**KIRKLEES COUNCIL
TOWN AND COUNTRY PLANNING ACT 1990
HIGHWAYS DEVELOPMENT MANAGEMENT**

PLANNING REF 2018/62/91621/W0/LY
CATEGORY Other

PROPOSAL ERECTION OF SINGLE AND TWO
STOREY REAR EXTENSION, FRONT
AND REAR DORMERS, FRONT
PORCH AND FORMATION OF
VEHICULAR ACCESS

LOCATION 35 HOLLY ROAD
THORNTON LODGE
HUDDERSFIELD
HD1 3SE

PROPOSED GROUND FLOOR PLAN

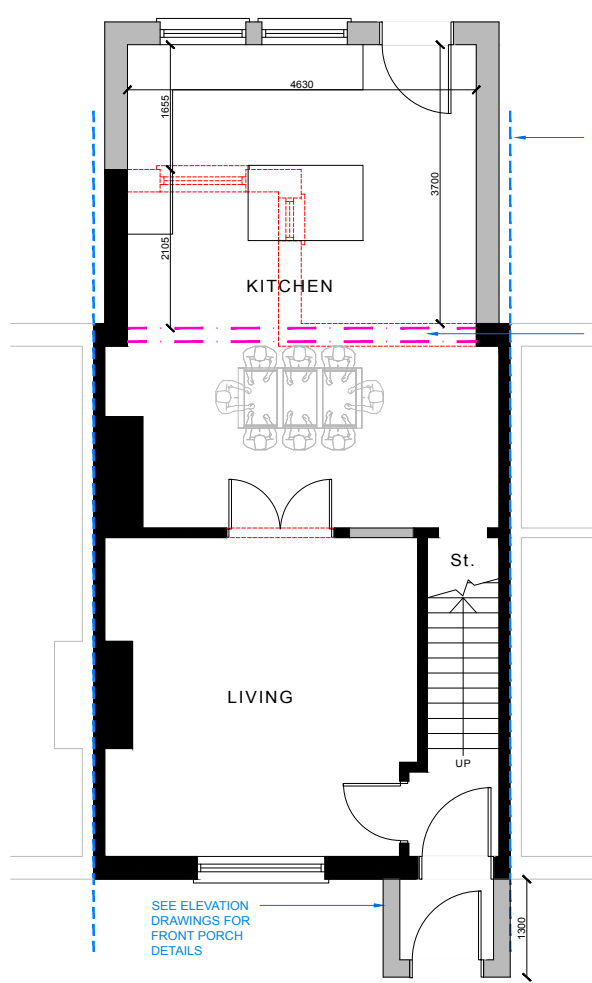
The proposed development would increase the number of bedrooms from three to four, extend the kitchen area, and provide two off-street parking spaces.

Although the potential additional off-street parking is welcomed, the proposed spaces would appear to be inaccessible by a medium-sized car. Whilst each measures 2.5m x 5.0m, they are both only 2.5m deep and 5.0m wide, so it would be extremely difficult to manoeuvre into either space without encroaching onto third party land, if it is possible at all.

PROPOSED SITE PLAN
Scale 1:100 at A3

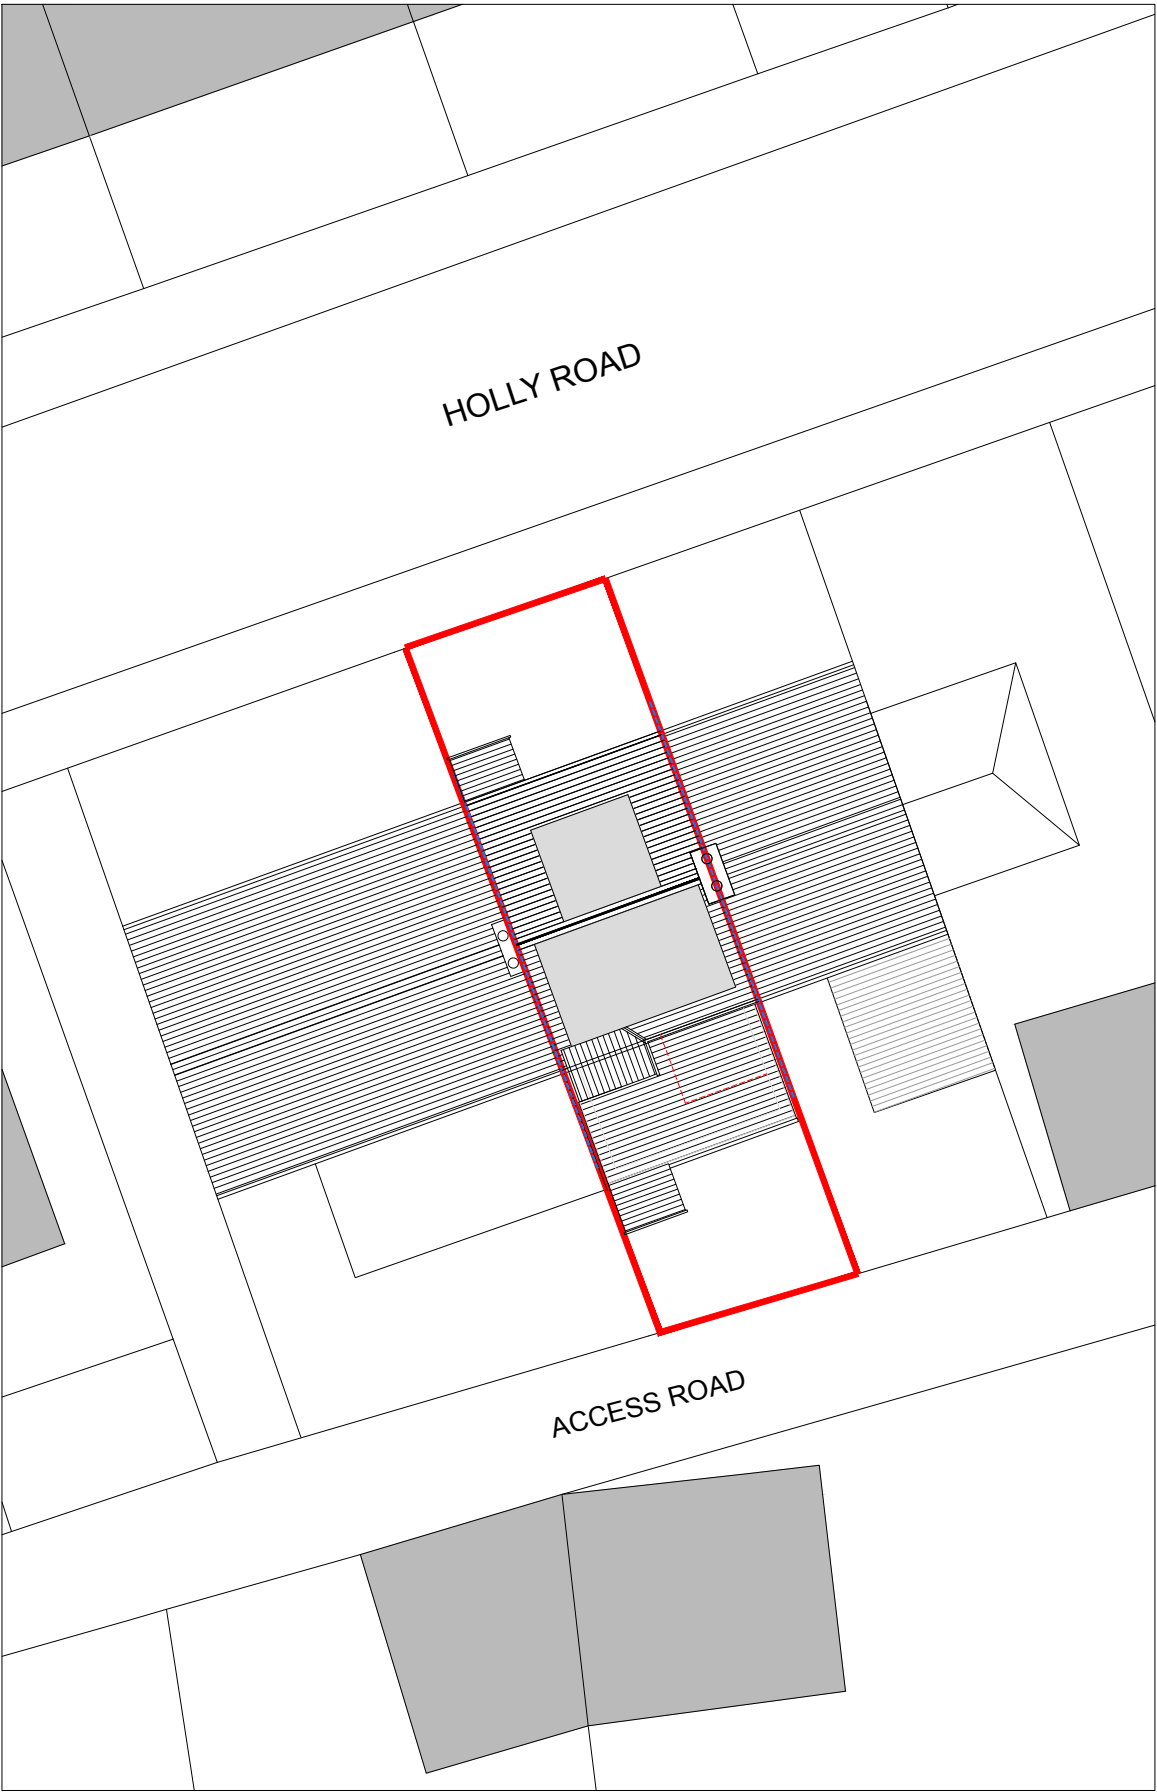
As it would be difficult to support the increase in size of the dwelling without the provision of off-street parking, Highways DM would ask for the following information:

- Swept path analysis for the access and egress of a large car from both proposed parking spaces.
